Our Case Number: ABP-317660-23

**Re:** Busconnects Kimmage to city centre core bus corridor scheme  
Kimmage, Dublin

## KIMMAGE TO CITY CENTRE CORE BUS CORRIDOR SCHEMELANDSCAPING AND URBAN REALM

Programme Title BUSCONNECTS DUBLIN CORE BUS CORRIDORS INFRASTRUCTURE WORKS				
Drawing Title KIMMAGE TO CITY CENTRE CORE BUS CORRIDOR SCHEME LANDSCAPING AND URBAN REALM				
Drawing File Name BCIDD-ROT-ENV_LA-0011_ML_00-DR-LL-0004	Sheet Number 04 of 14	Status A	Rev M01

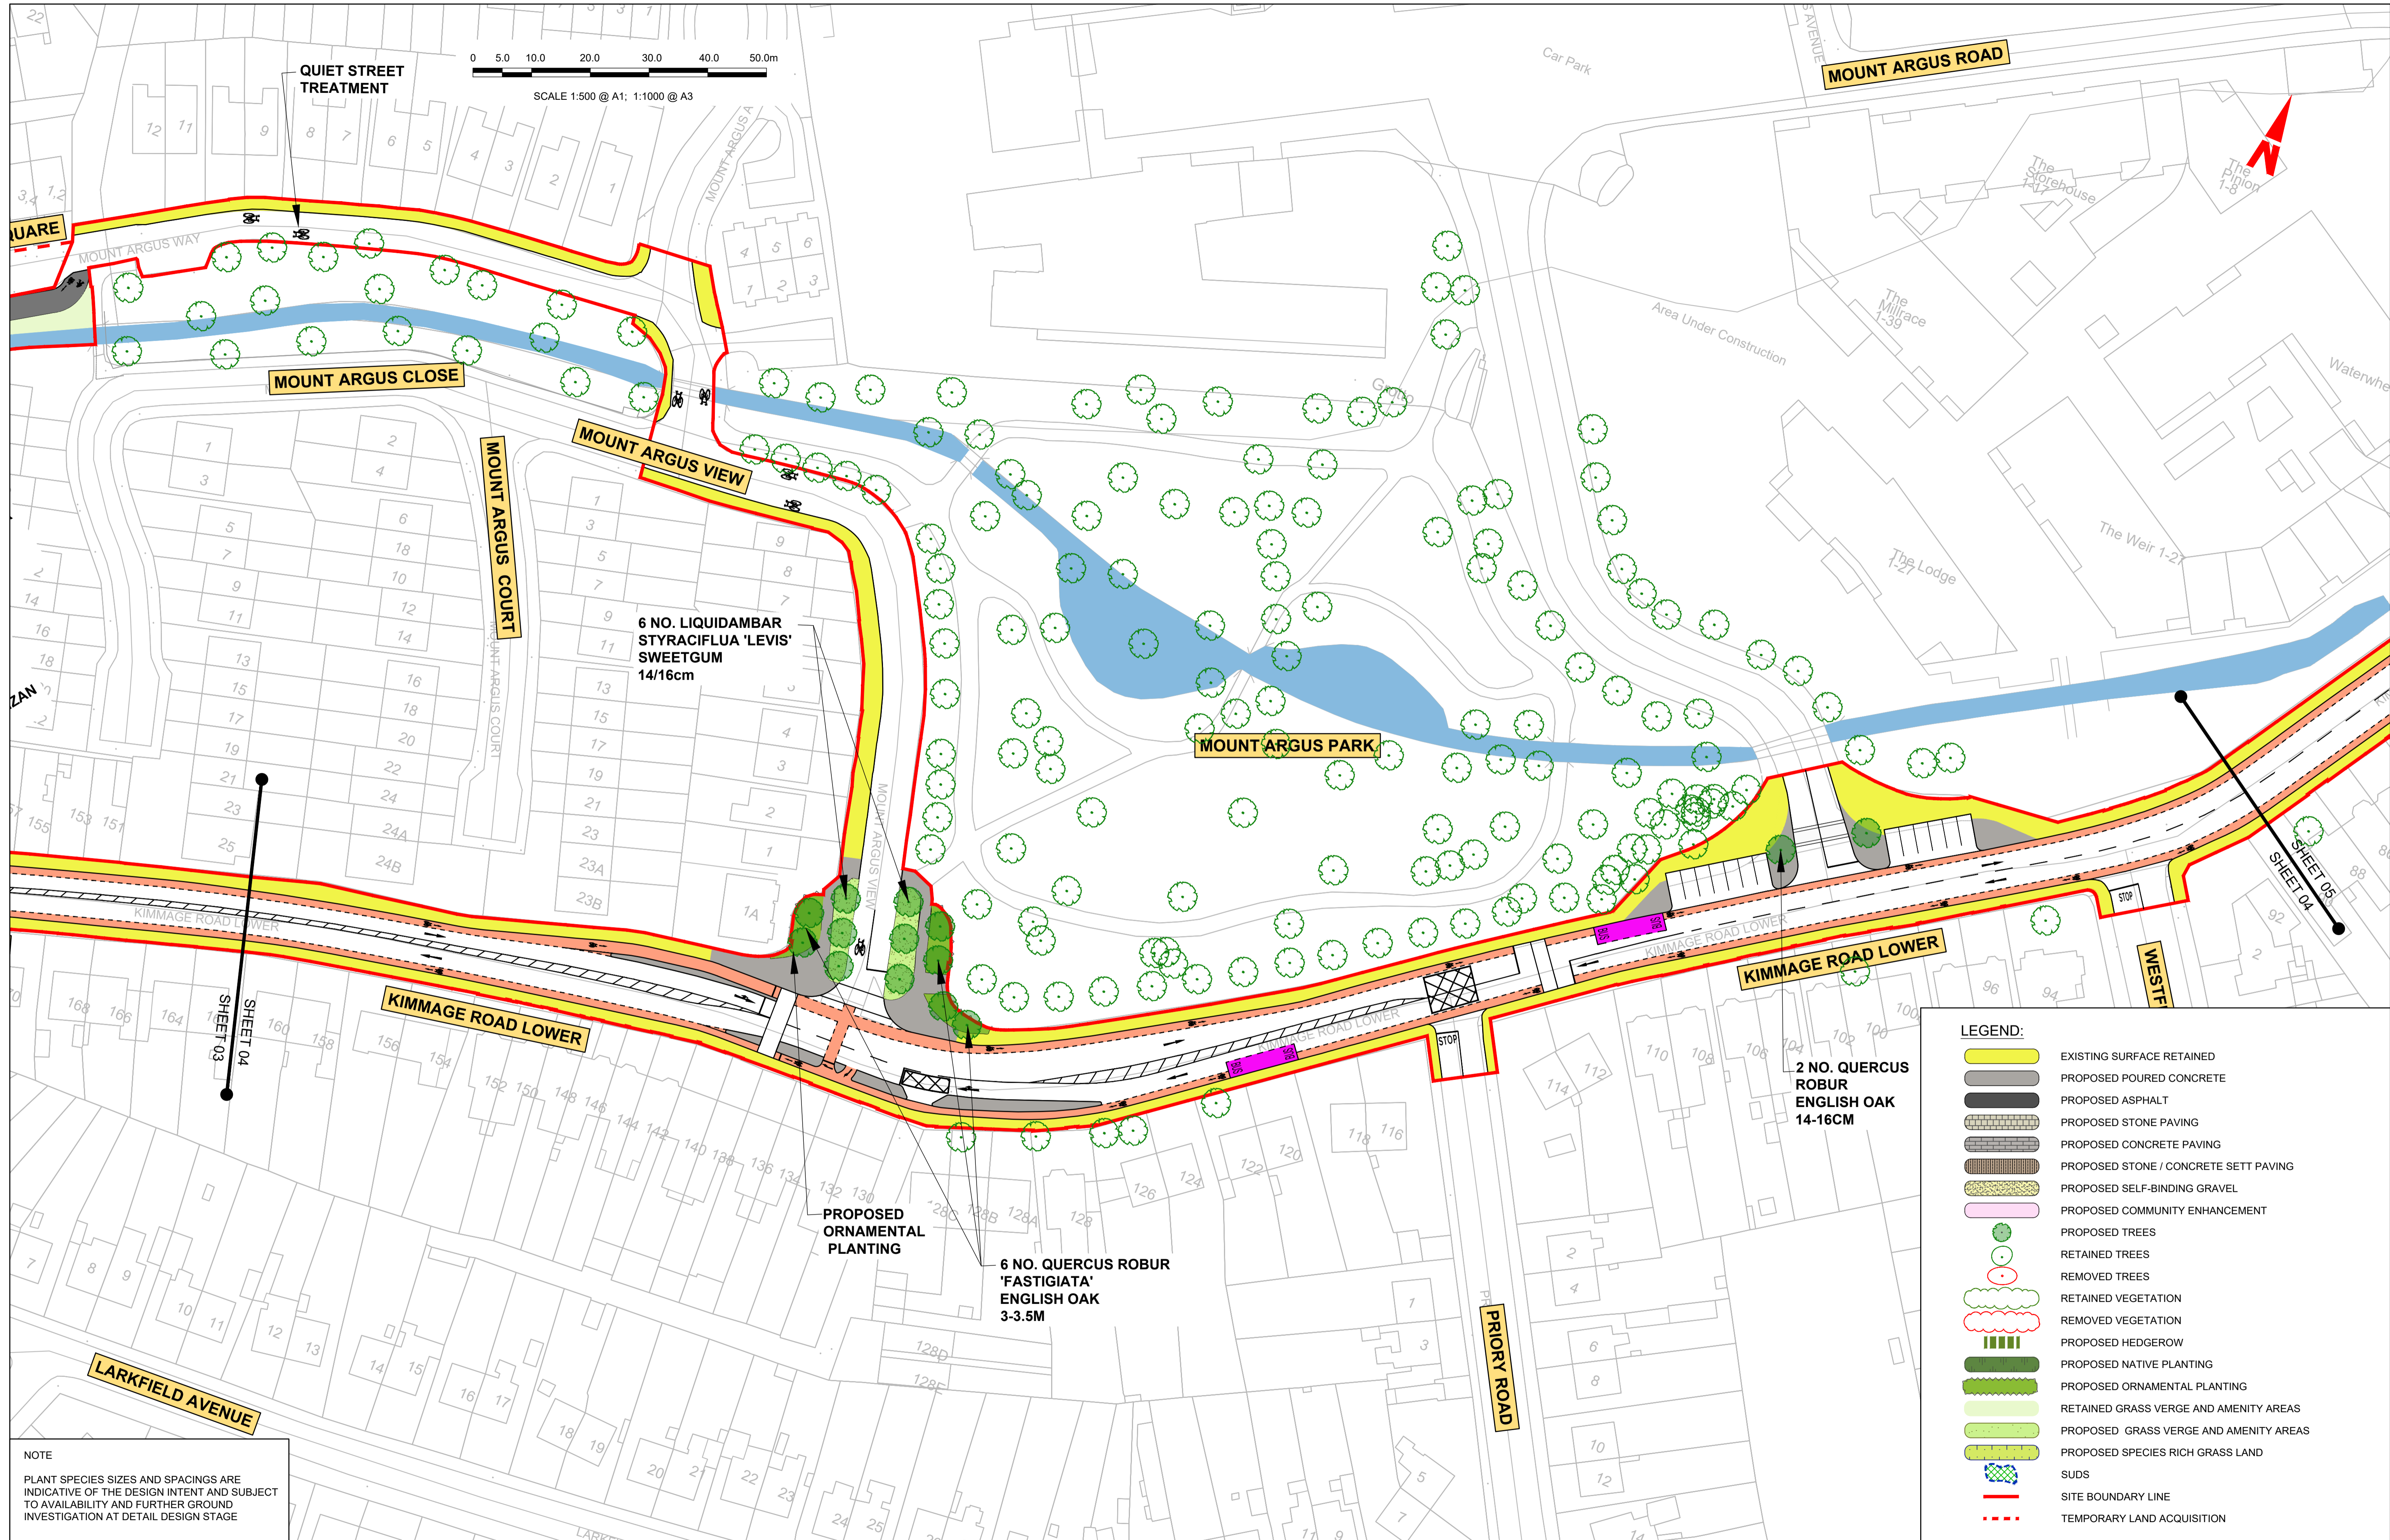
There are existing telephone / light / sign poles which are poorly located which prevent two way walking traffic due to minimum distance between poles & boundary wall to the footpath. The concrete foot paths have been shown as yellow indicating no amendment to locations. This poles should be repositioned while the works are underway. These poles should be repositioned while the

improvement works are underway. Suggest survey carried out to determine locations to full layout (sheet 1 – 14) and correct amend within layouts. See below photo for example.

Drawing File Name	Sheet Number	Status	Rev																																																
BCIDD-ROT-ENV_LA-0011_ML_00-DR-LL-0005	05 of 14	A	M01

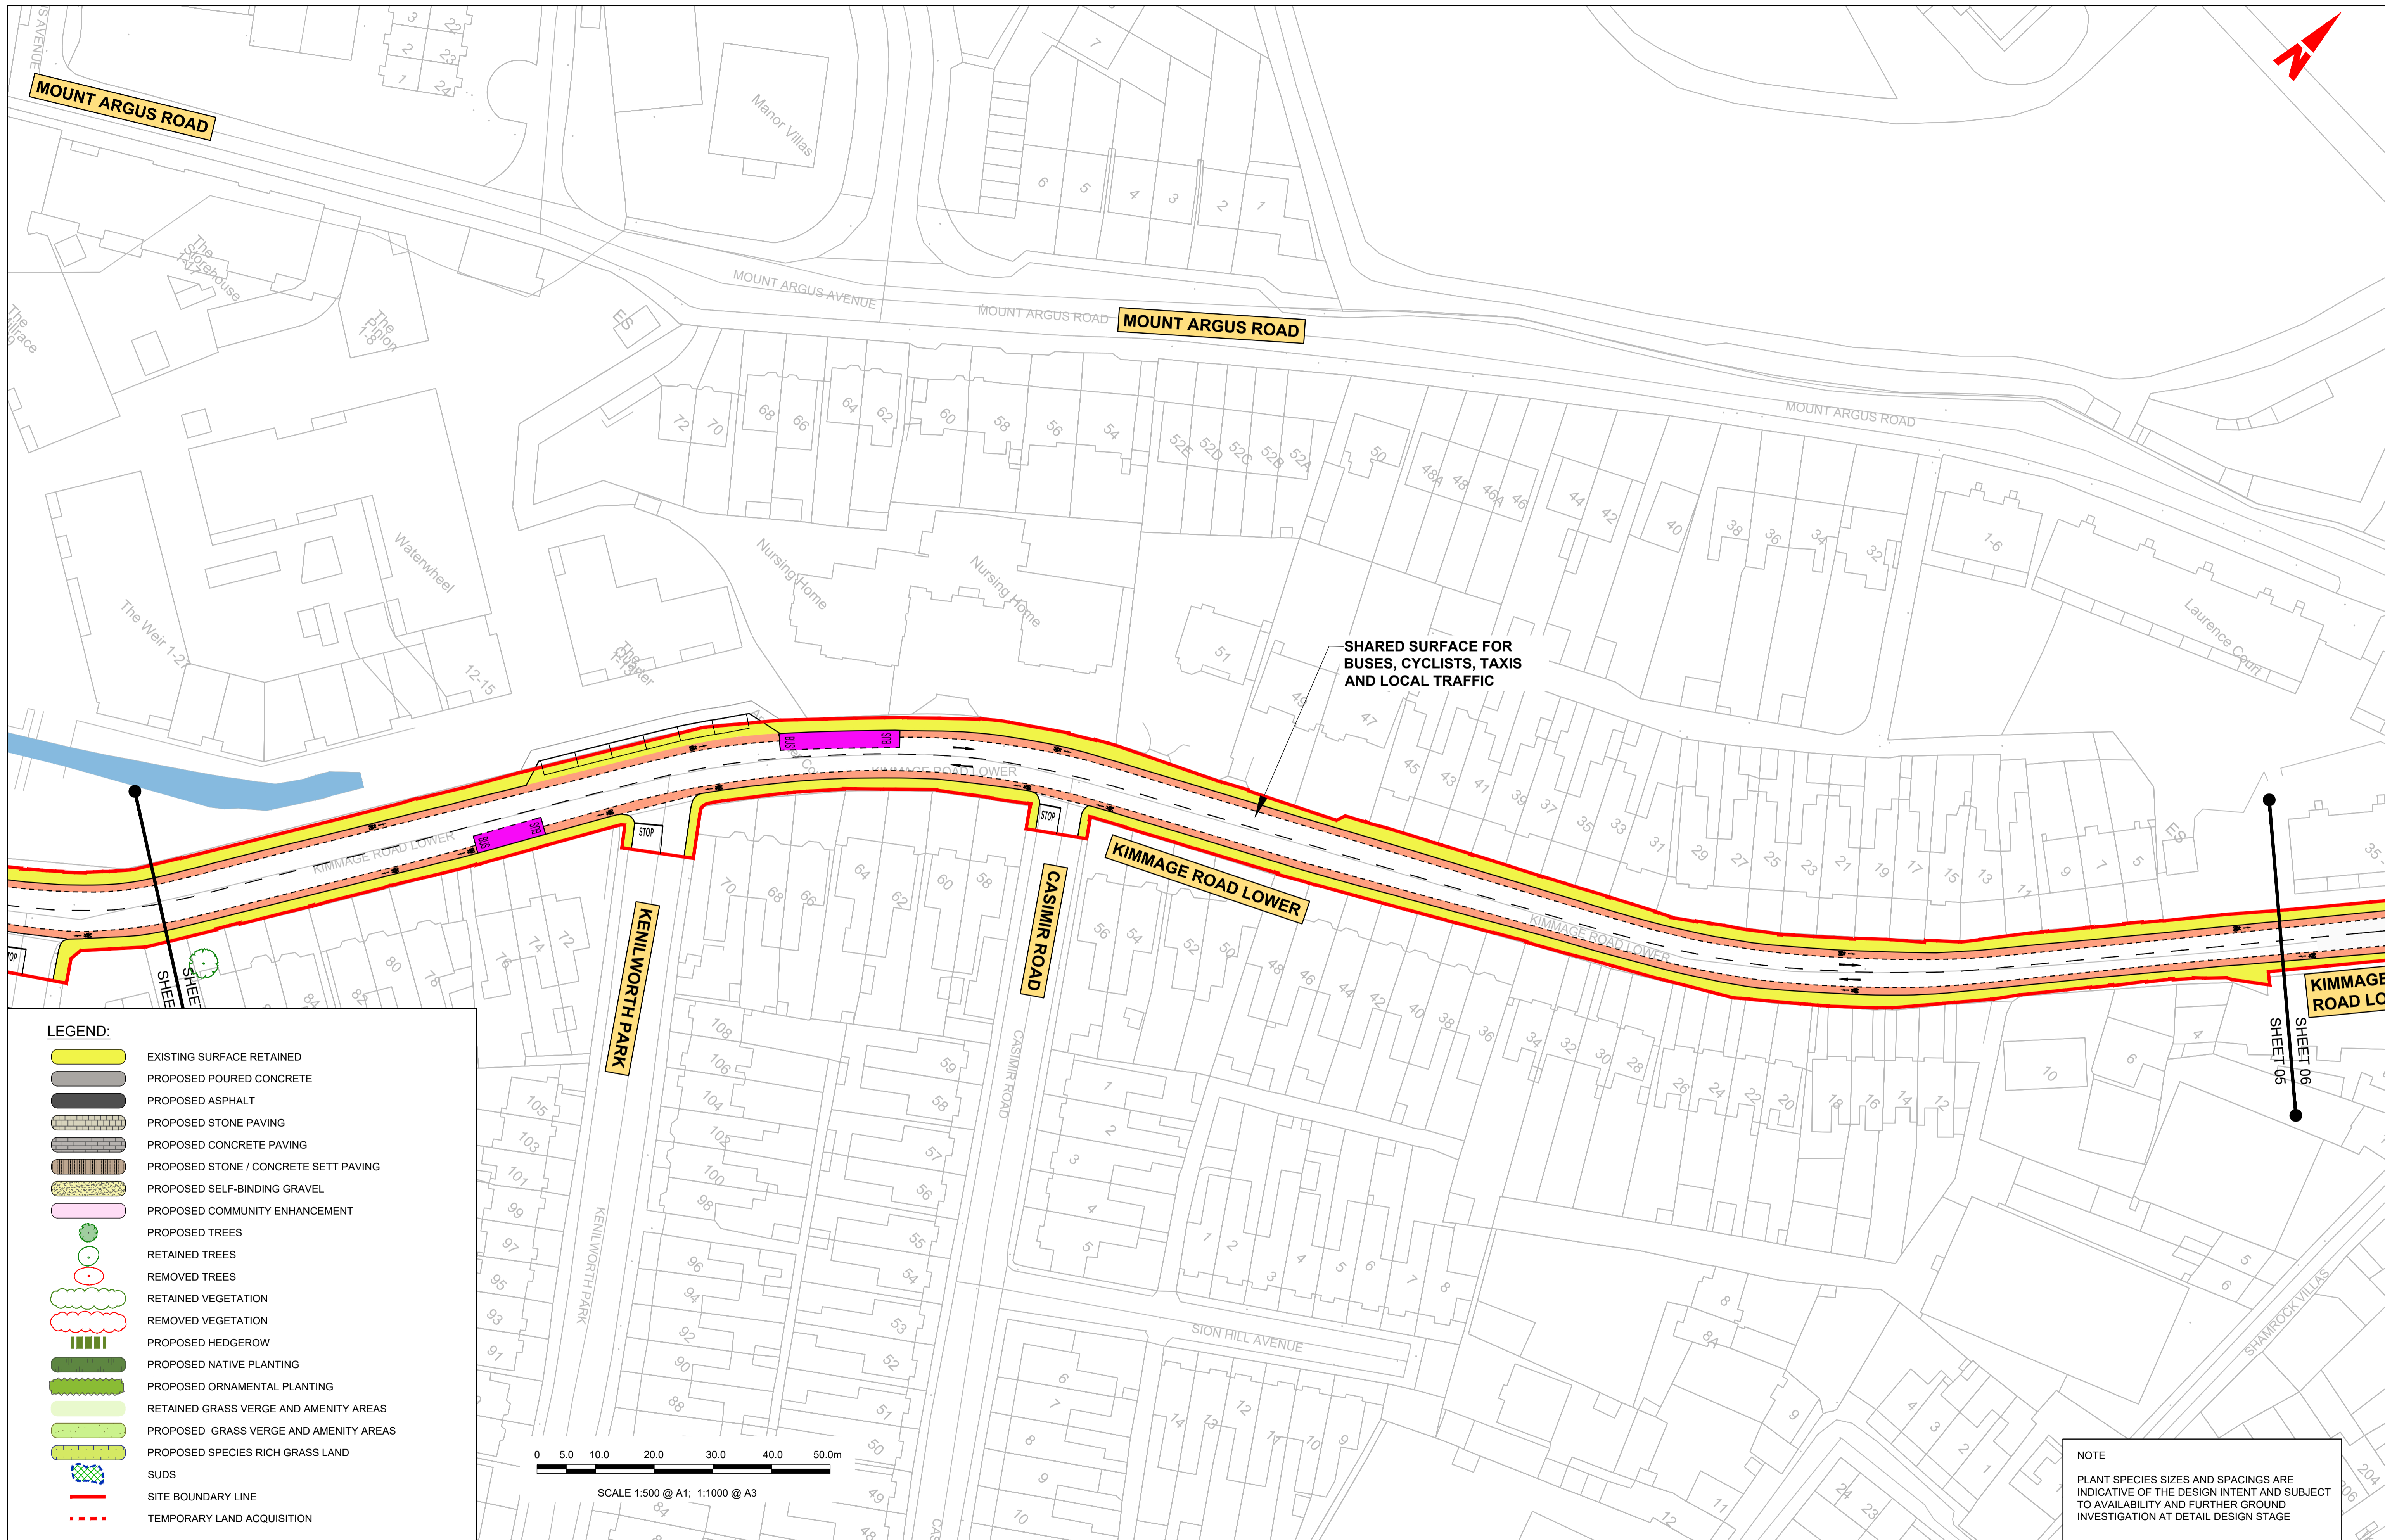
There are existing telephone / light / sign poles which are poorly located which prevent two way walking traffic due to minimum distance between poles & boundary wall to the footpath. Suggest survey carried out to determine locations to full layout (sheet 1 – 14) and correct amend within layouts.

Programme Title BUSCONNECTS DUBLIN CORE BUS CORRIDORS INFRASTRUCTURE WORKS			
Drawing Title KIMMAGE TO CITY CENTRE CORE BUS CORRIDOR SCHEME LANDSCAPING AND URBAN REALM			
Drawing File Name BCIDD-ROT-ENV_LA-0011_ML_00-DR-LL-0006	Sheet Number 06 of 14	Status A	Rev M01

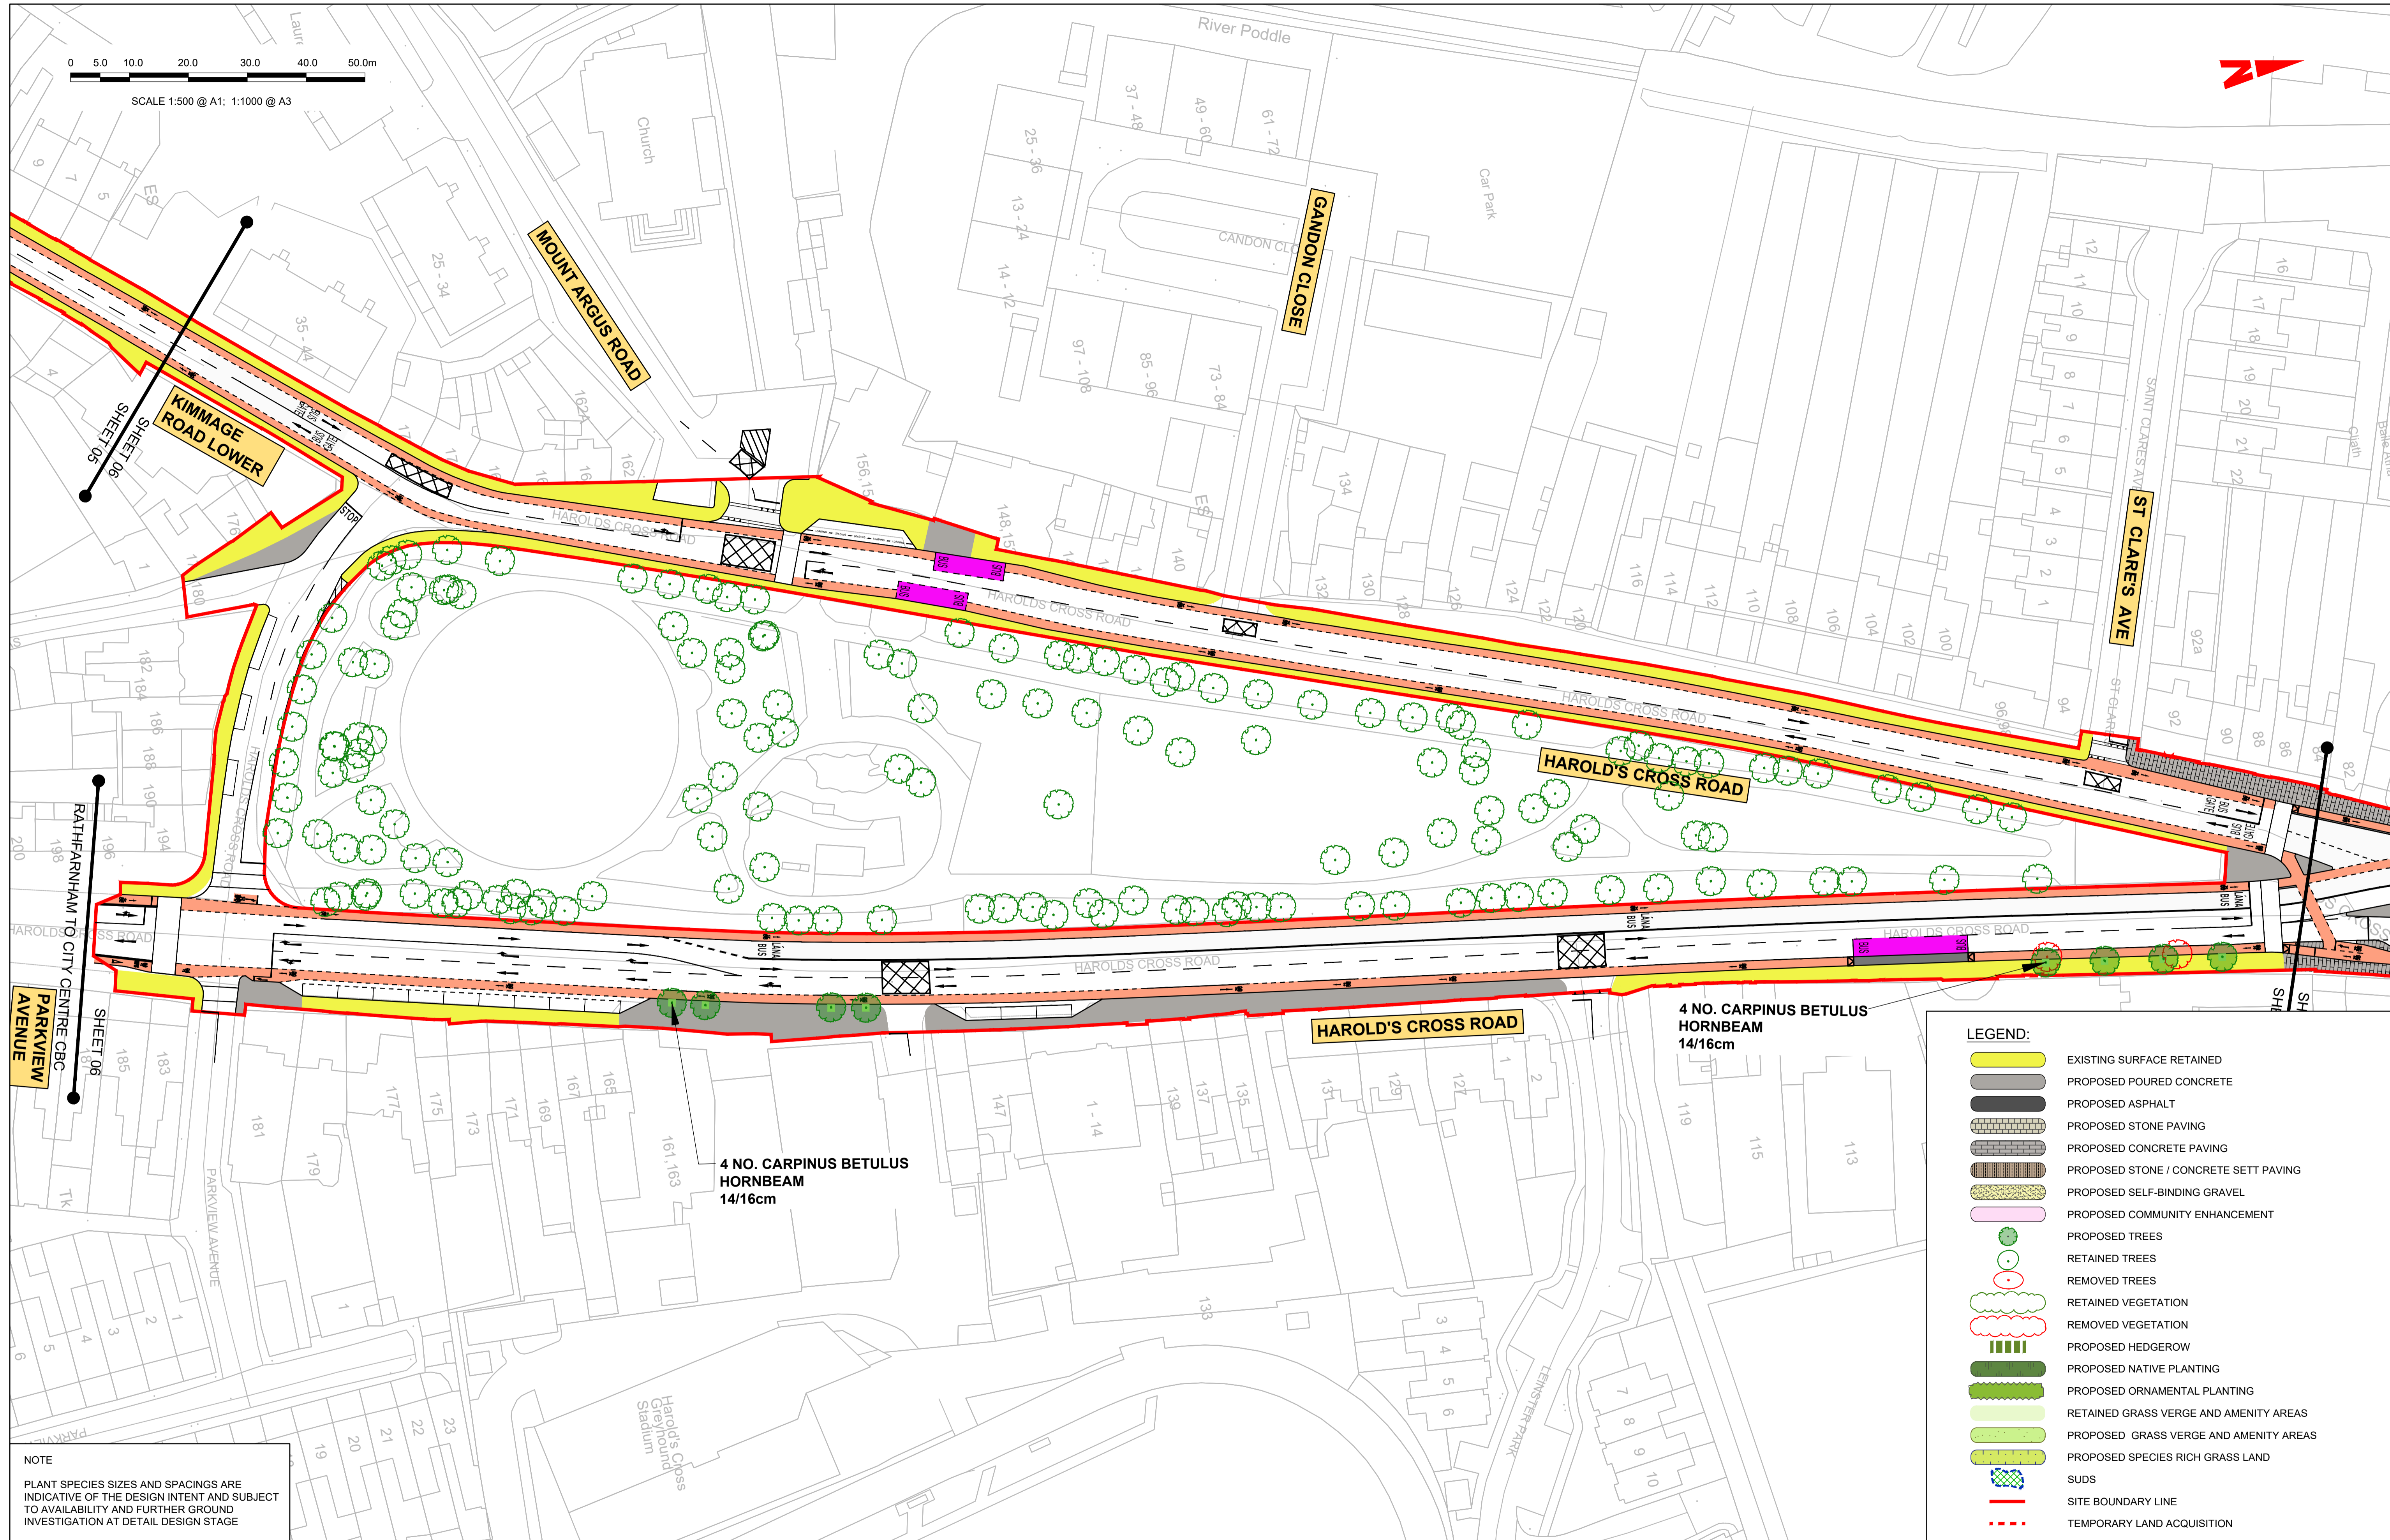
As above, granite paving and more ambitious public landscaping / street furniture should be provided.
